DRB CASE ACTION LOG (FINAL PLAT)

DRB Application No.: **04DRB-01308 (FP)**

Project Name: **VISTA WEST SUBDIVISION**

**CITY OF ALBUQUERQUE
PLANNING DEPARTMENT
September 1, 2004
DRB Comments**

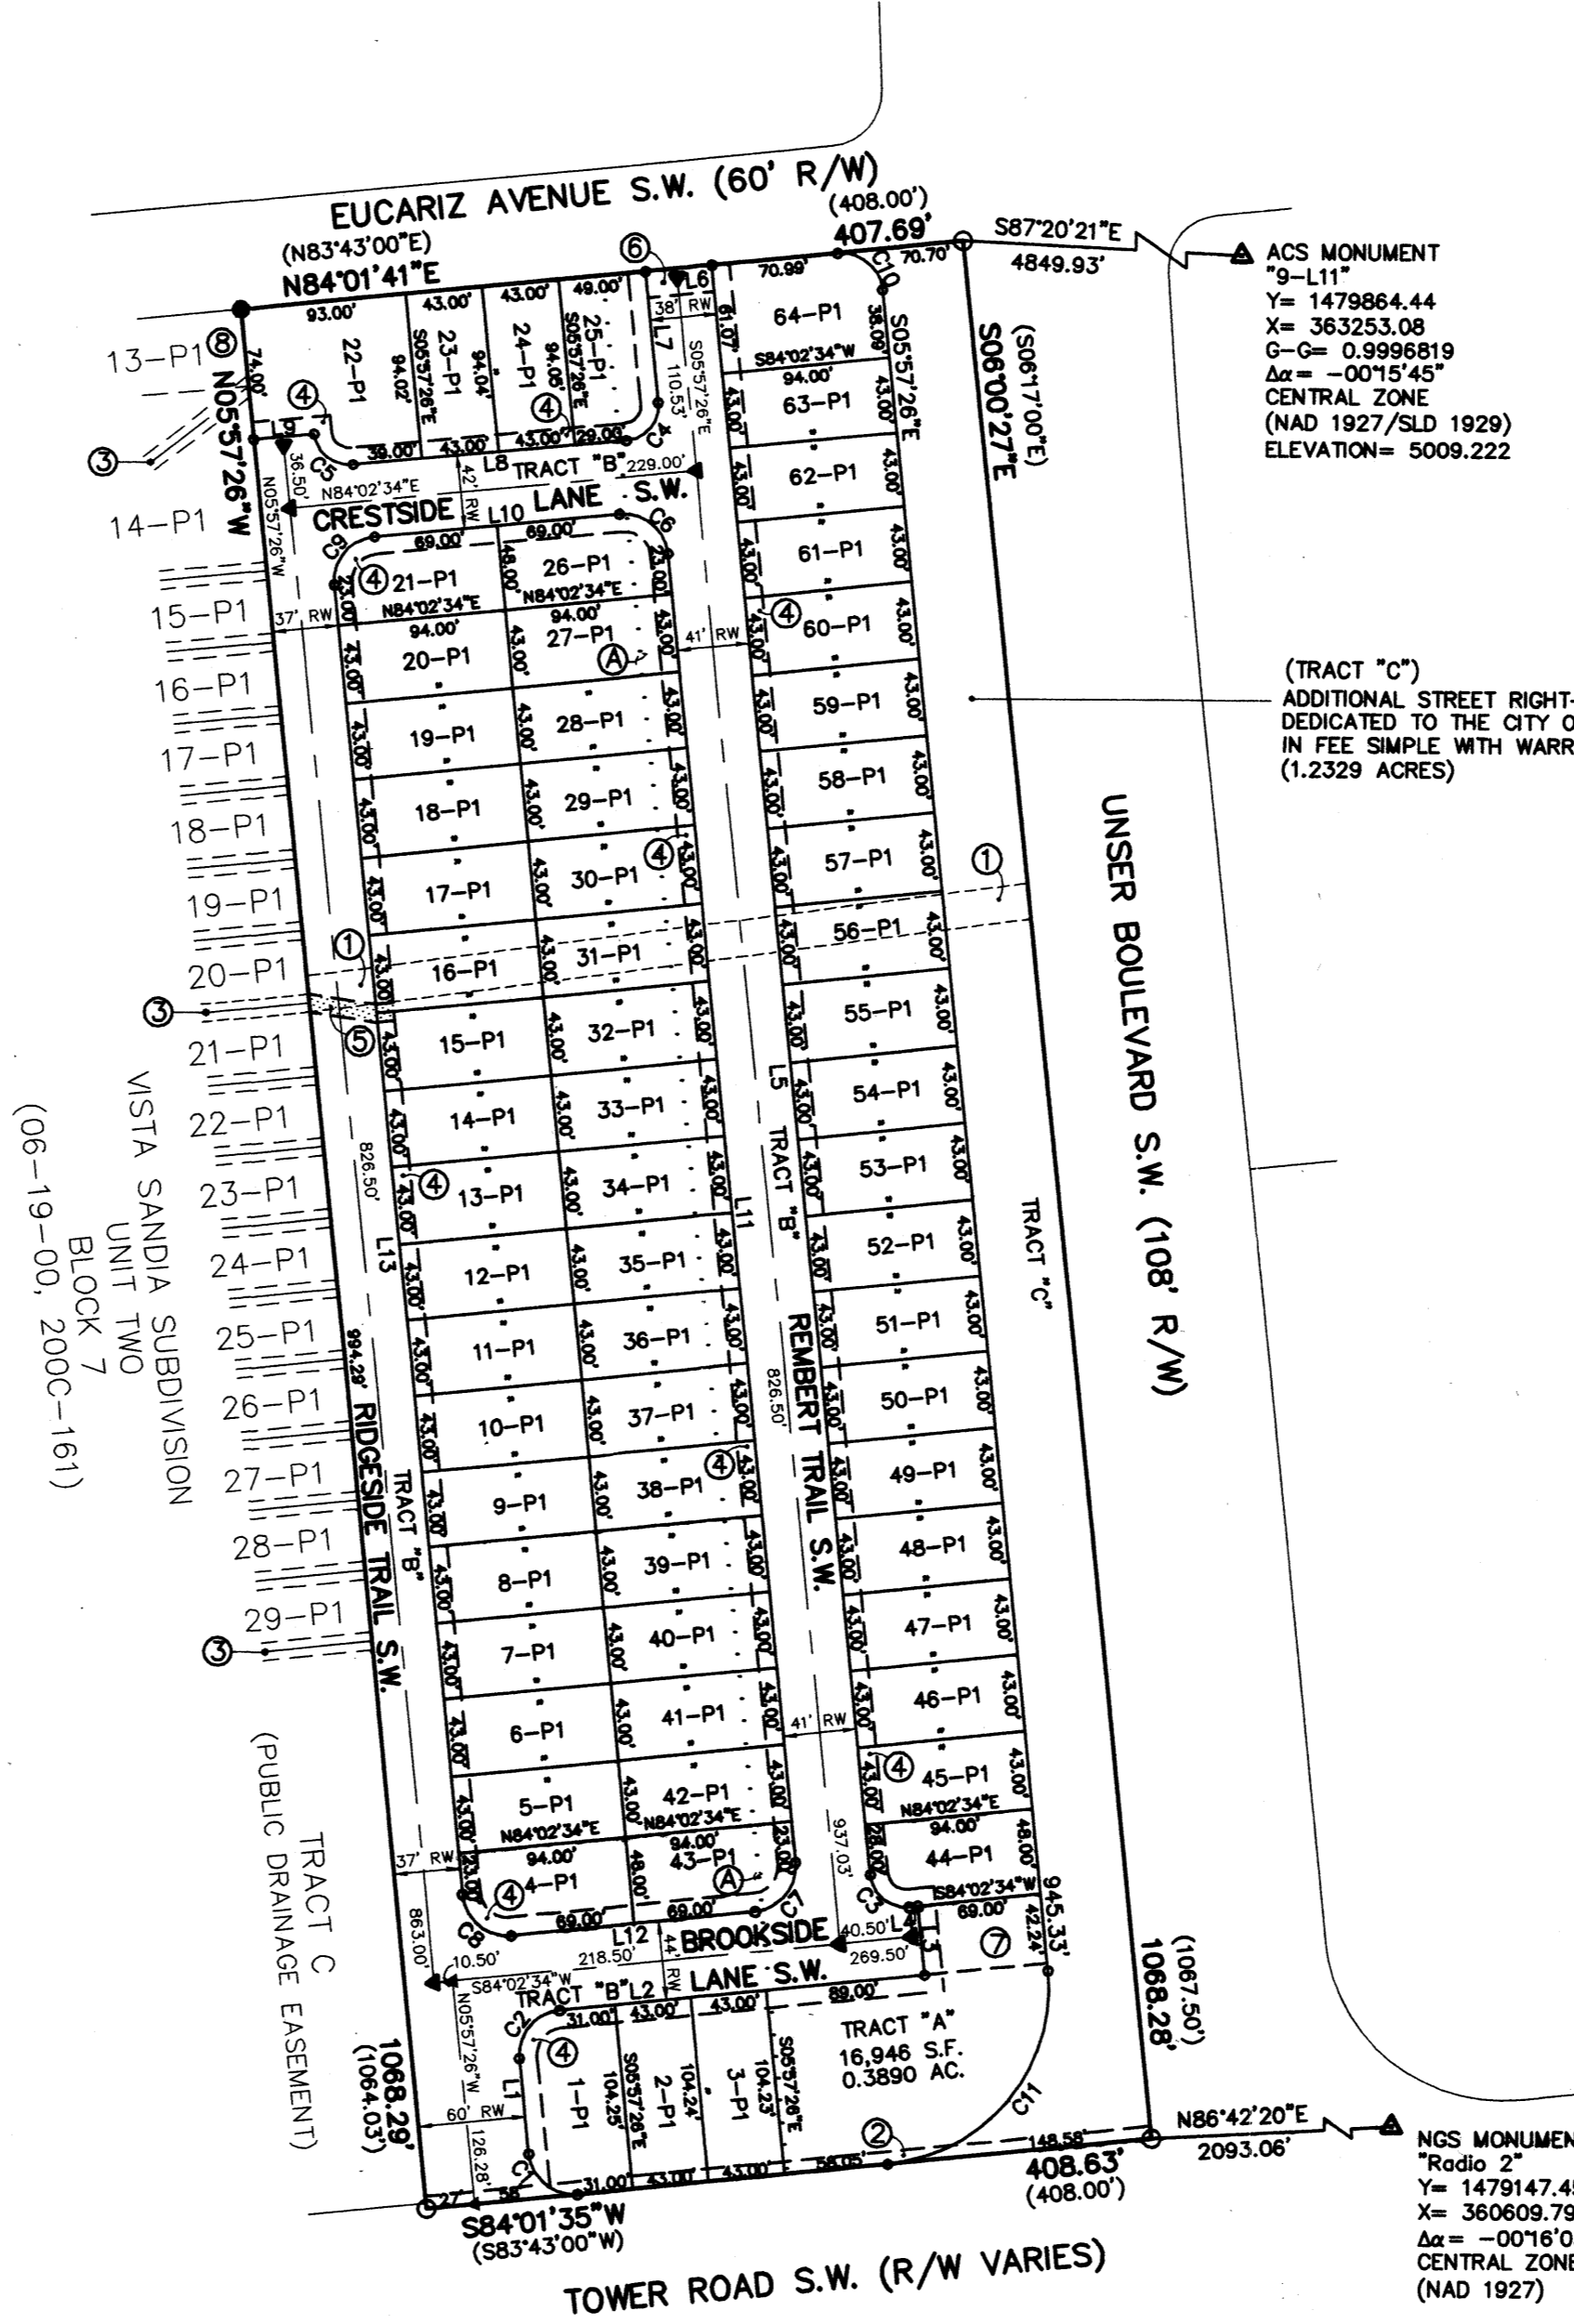
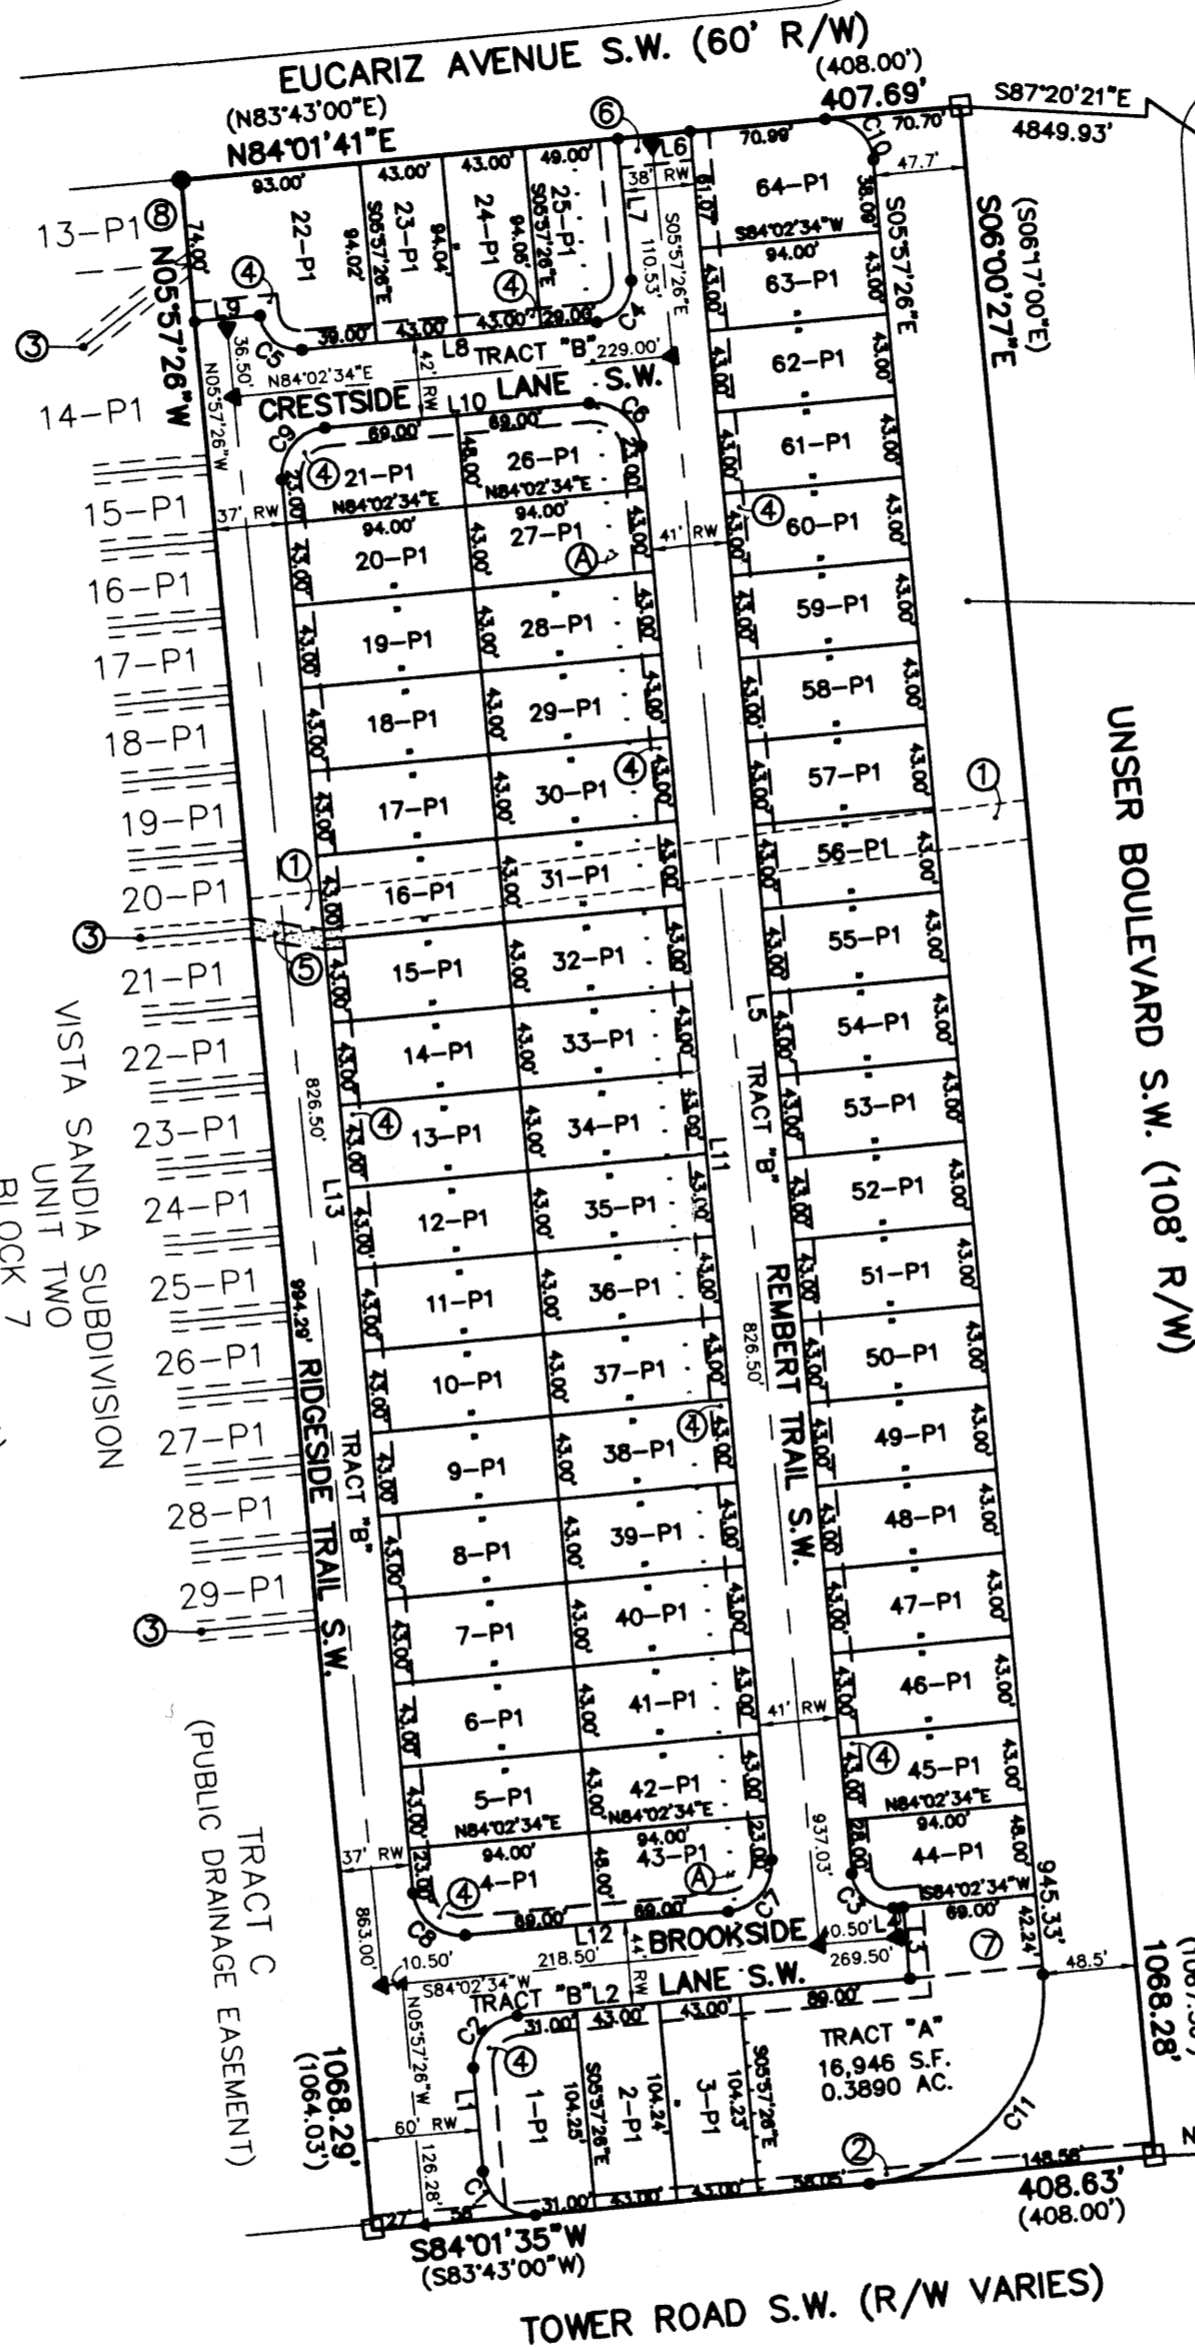
The perimeter wall design submittal note on the pilaster and cap should state they will project at least 2 inches on the public side. The second page shows a list of plants. Where is the landscaping to be planted? A small version of the plat is needed to show the location of the perimeter walls and the landscaping. If the landscaping is planted in the public right of way, a landscape maintenance agreement is required on the infrastructure list along with the separate irrigation water meter. Planning will sign the final plat after the wall design is approved.

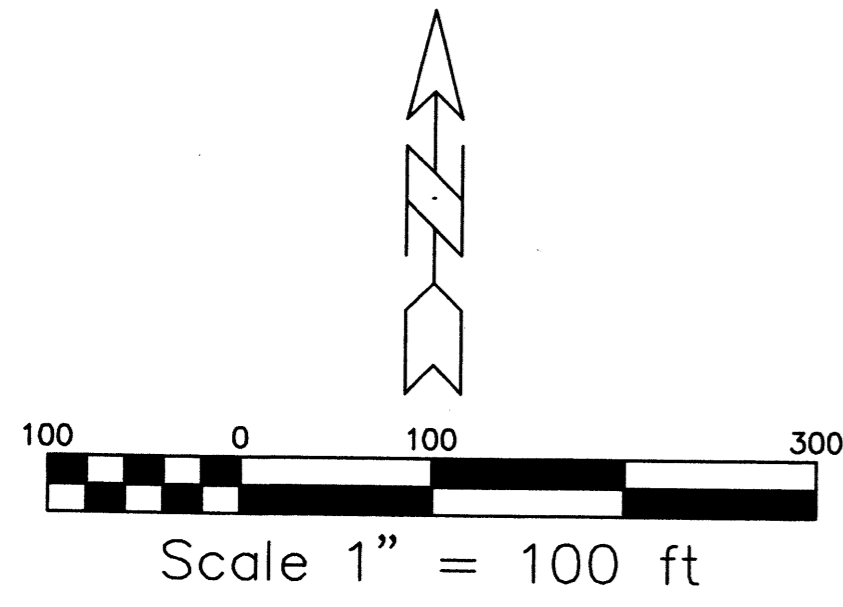
Defer to agencies affected by the requested action. Unclear if only the 20' MST&T easement is being requested?
